From: RATHAN Pahee <Pahee.RATHAN@rms.nsw.gov.au>
Sent: Thursday, 22 September 2016 5:15 PM
To: Kerry Hamann
Subject: RE: Notification of modification request - Joe White Maltings - Minto (Campbelltown LGA)

I refer to your email below regarding the modification application by Joe White Malting to increase the material delivered by road from 54,000 tonnes to 157,000 tonnes.

Figure 4-6 Rose Payten Dr / Pembroke Rd

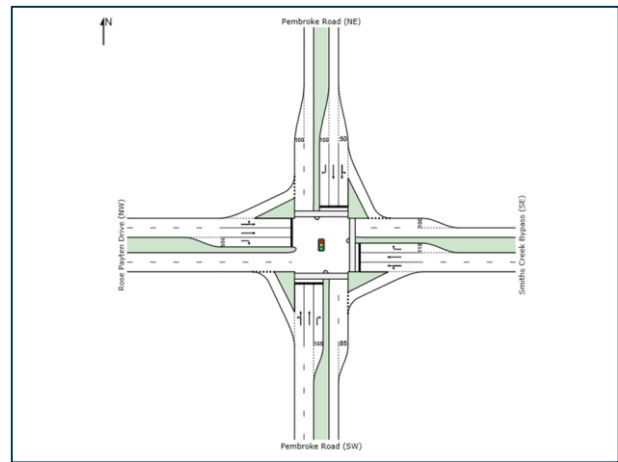
2. The traffic report indicates that the signalised intersection of Rose Payton Drive/Pembroke Road and Campbelltown Road/Rose Payten Drive will operate at Level of Service F in 2016. Furthermore, it is noted that some of the movements at these intersections currently (2016) operate at Level of Service F. The applicant is to identify the required mitigation measures to ensure these intersections operate at an acceptable level, now and in the future.
